DESIGN EXCELLENCE STRATEGY

Construction of a Mixed Use Development
including Commercial/Retail Uses and Hotel
Accommodation
42 Honeysuckle Drive, Newcastle NSW 2300

Table 1 – Comment and Response to DRP

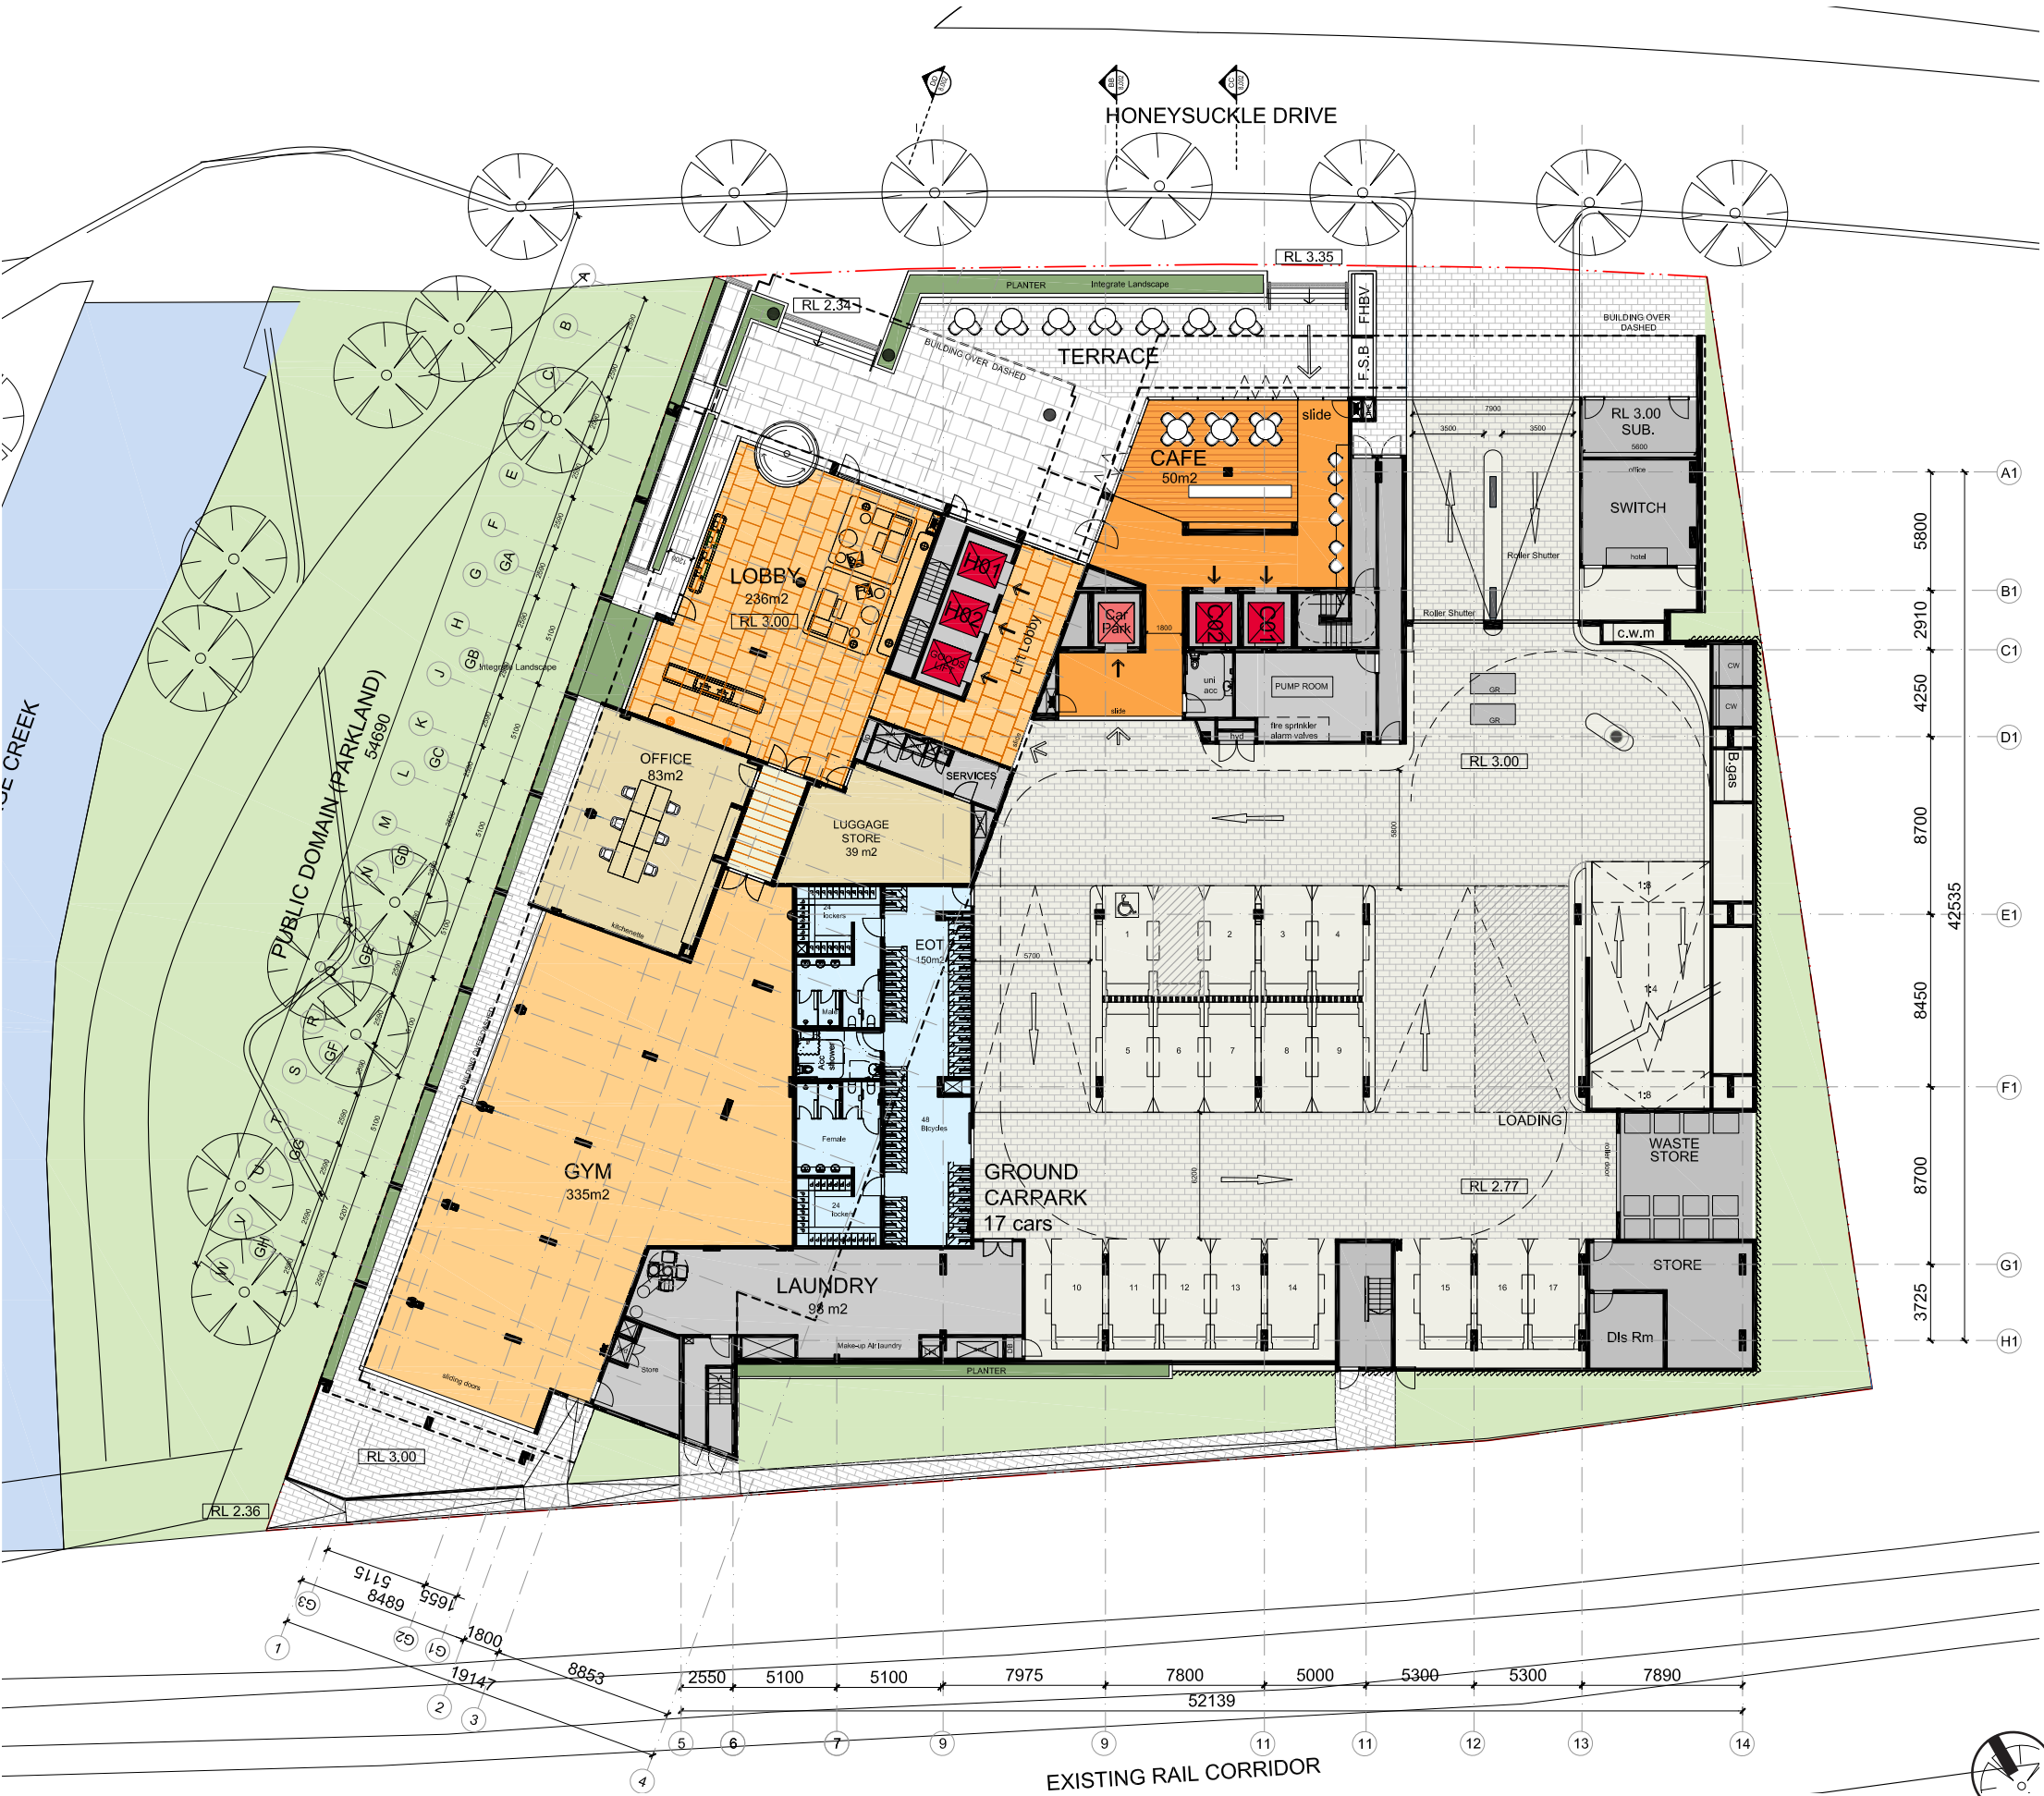
DRP Comments, Notes and Queries	Response
<p>The accessibility ramp should be reconsidered, to achieve access that more naturally integrates disabled access with stairs and entry ways.</p>	<p>Since the presentation with the DRP, the accessibility ramp position has been explored further, however given the flooding risk on-site the proposed location is the only position to fulfil civil design requirements.</p> <p>A covered ramp length has been increased along the western edge of the site. At the “switch back” there is level access and an opportunity to enter the lobby space through a compliant door or using the circular sliding doors facing Honeysuckle Drive.</p>
<p>Questions were asked about the impact of wind on the podium top terrace, especially with regards to the funnel shape of the plan.</p>	<p>The impact of wind on the podium top terrace, especially with regards to the funnel shape of the plan are being investigated further and mitigation devices will be put in place.</p>

8.6 CARPARK FACADE

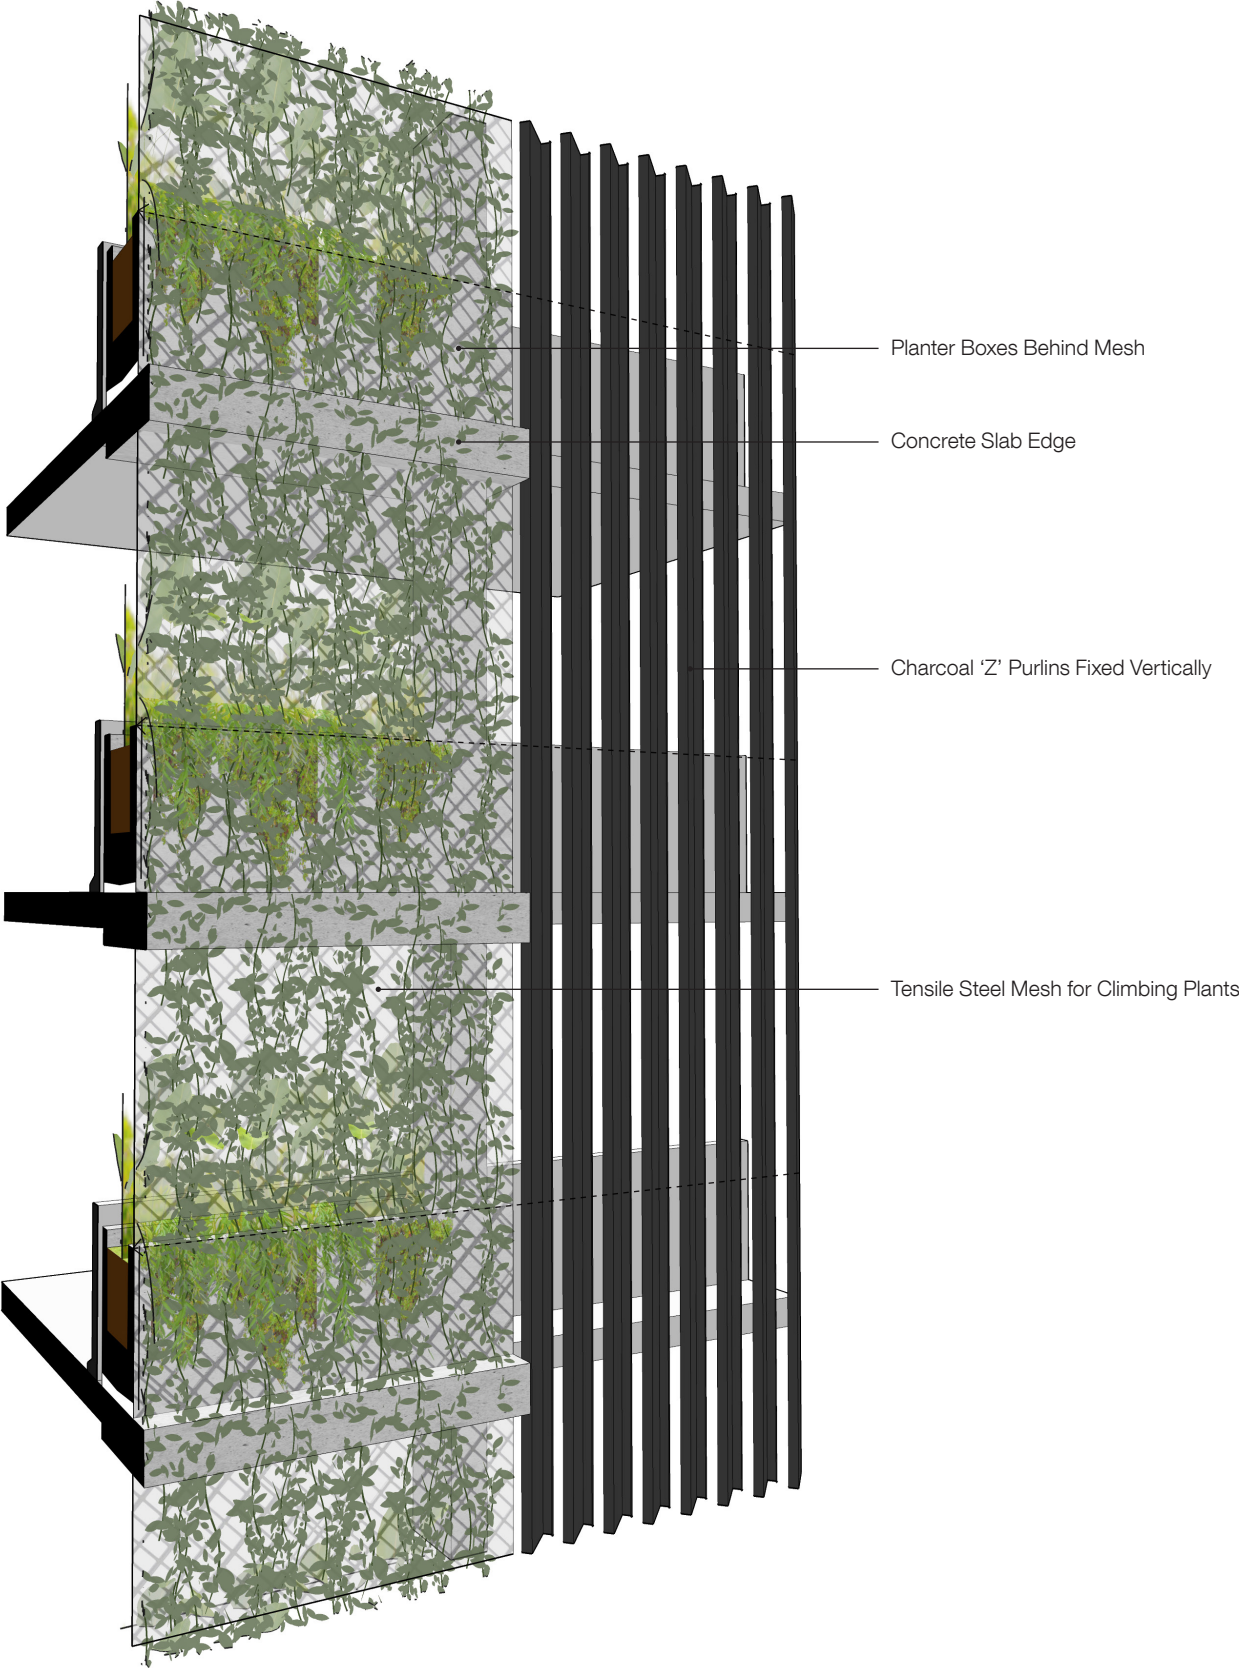
<p><i>The planting scheme for the car park was supported, DRP noting that UTS have done some good research on appropriate plants for this use.</i></p>	<p>Noted. Bates Smart in conjunction with the landscape architect have reviewed different plant species and have landed on numerous different species as shown below:</p>

DRP Comments, Notes and Queries	Response
<div><p>GREEN WALL PLANTING - southern aspect</p><div><p><i>Bergonia</i> spp.</p></div><div><p><i>Hoya australis</i></p></div><div><p><i>Monstera deliciosa</i></p></div><div><p><i>Cissus antarctica</i></p></div><p>GREEN WALL PLANTING - eastern aspect</p><div><p><i>T. jasminoides</i></p></div><div><p><i>Kennedia rubicunda</i></p></div><div><p><i>Hibbertia scandens</i></p></div><div><p><i>Pandorea jasminoides</i></p></div></div>

South Elevation

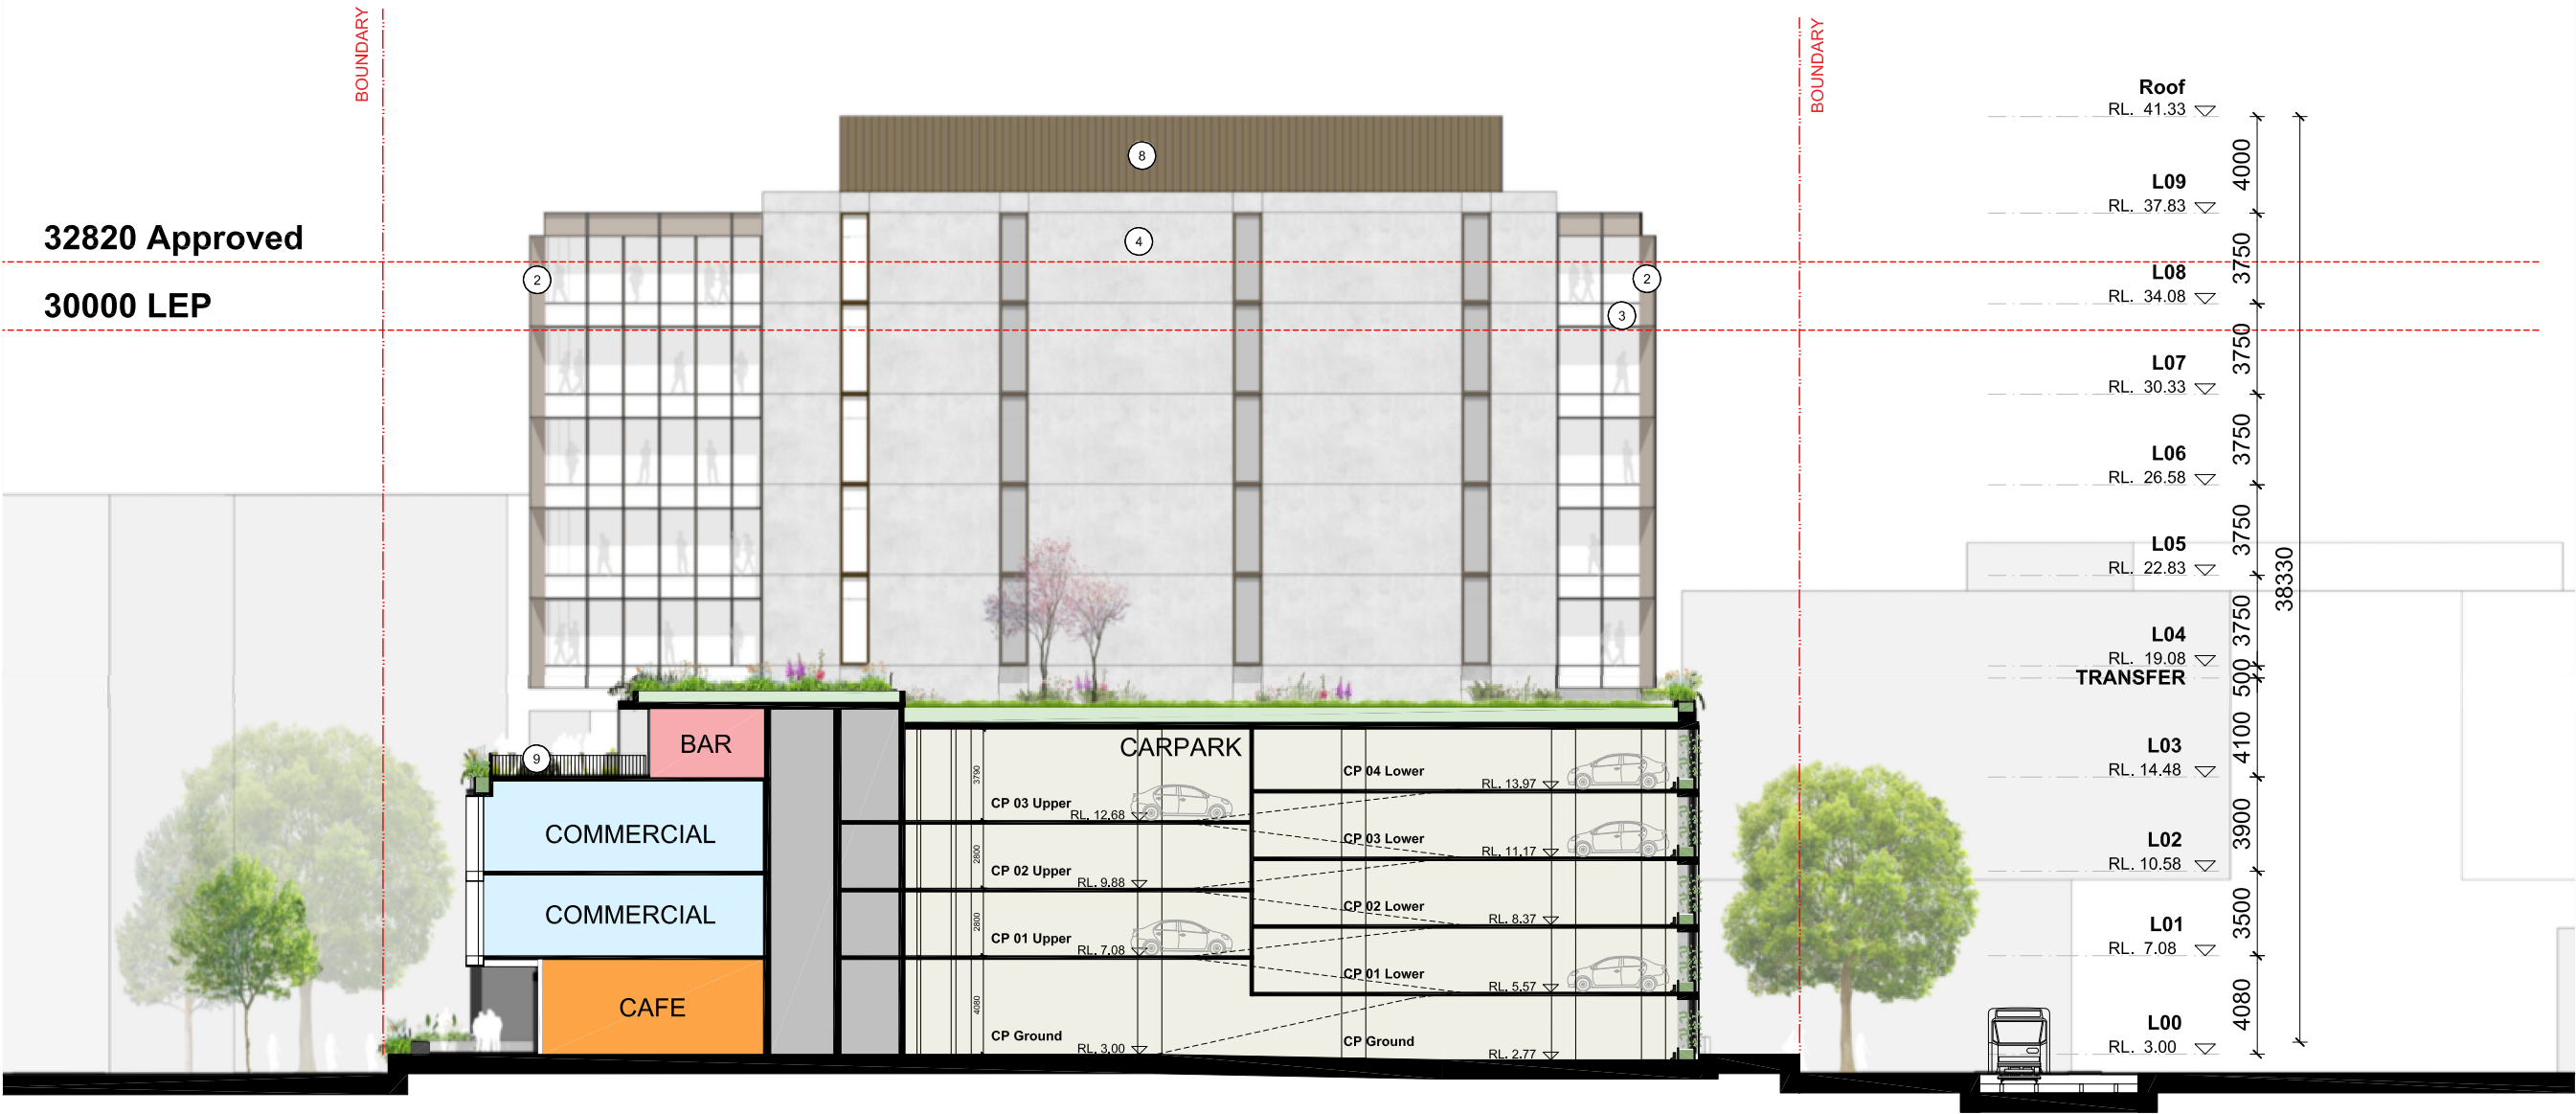
<p><i>The southern elevation faces directly to the light rail line, with no pedestrian, private vehicle or bicycle routes along that side. However, this elevation still must be considered when viewed from the light rail and from the path coming across from Hunter St. The composition is generally acceptable however it appears very unactivated, due to the position of car parks, end walls of hotel rooms etc.</i></p>	<p>The revised design seeks to improve the overall built form arrangement providing an improved amenity outcome for hotel guests and seeks to alter the land uses to cater for the market demand for commercial office space.</p> <p>The proposal seeks to provide a green wall on the southern façade to provide a more interesting façade from the light rail. It is acknowledged that the design seeks to the south-western façade as this interface will be highly visible to pedestrians given the provision of the bicycle route.</p>
